**Section 96A of the Town & Country Planning Act 1990 (as amended)
Town and Country Planning (Development Management Procedure) (England) Order 2015 (as amended) - Article 10**

Non-material amendment following the grant of reference FG/122/17/HH for rectangular lantern instead if square in garden room, window to utility room insted of door, forward projection of garage from house 3090, height of garage now 2900 to top of coping on parapet, removal of 2 No. window openings in garage wall, 1 sqm roof light in garage, 3 panes in bifold instead of 4 and bedroom window wider with 2 opening lights.

5 Sea Drive Ferring BN12 5HD

drawing  
Proposed Ground Floor Plan

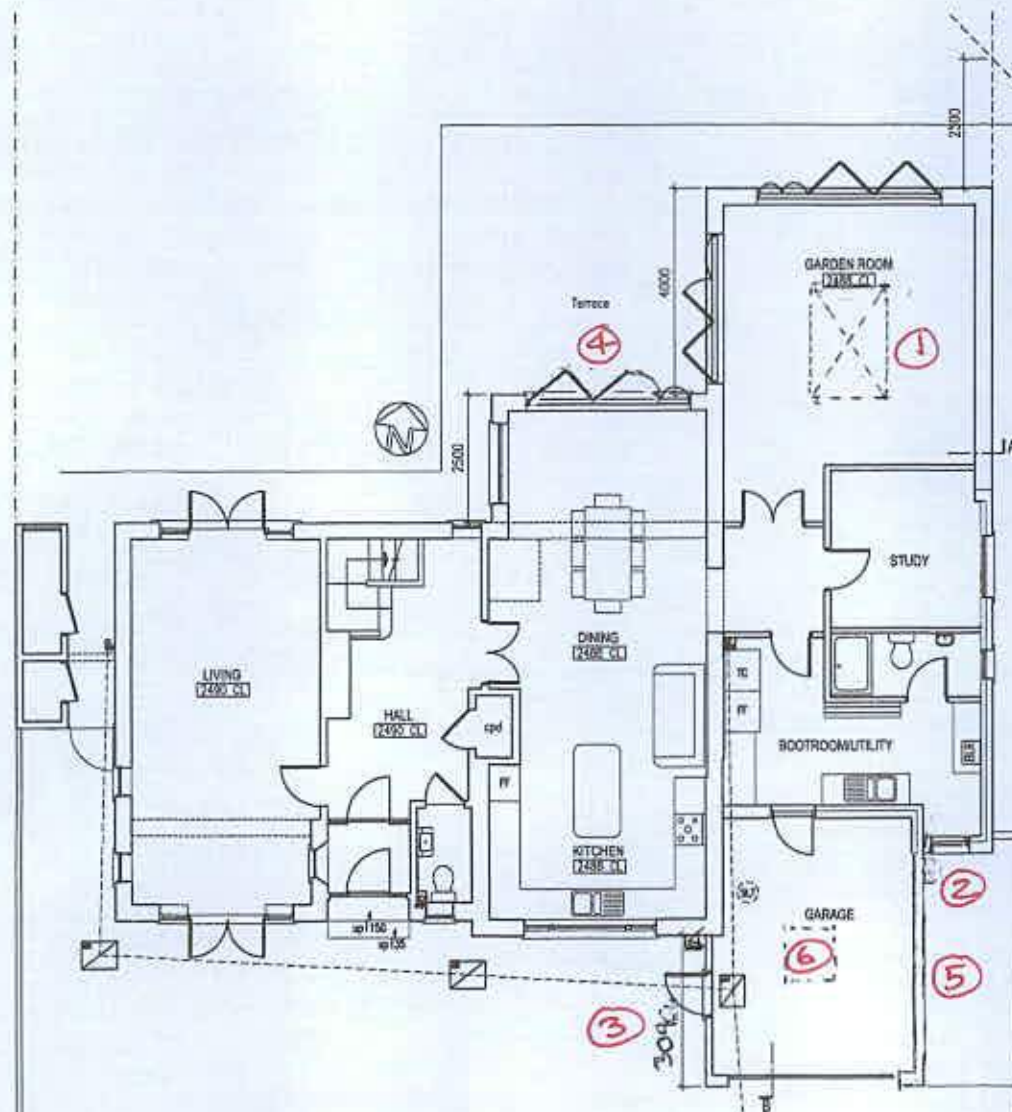
From the information submitted I am able to take the alterations detailed namely: rectangular lantern instead if square in garden room, window to utility room insted of door, forward projection of garage from house 3.09m, height of garage now 2.9m to top of coping on parapet, removal of 2 No. window openings in garage wall, 1 sqm roof light in garage, 3 panes in bifold instead of 4 and bedroom window wider with 2 opening lights. as a Non Material Minor Amendment to FG/122/17/HH. Drawing numbers 005 AW1 revD Proposed Ground Flor Plan, 006 AW1 revF Proposed Elevations and Sections, 007 AW1 rev F Proposed Elevations and 009 AW1 revD Proposed Roof Plan have therefore become the approved elevation and roof plans for planning permission FG/122/17/HH.
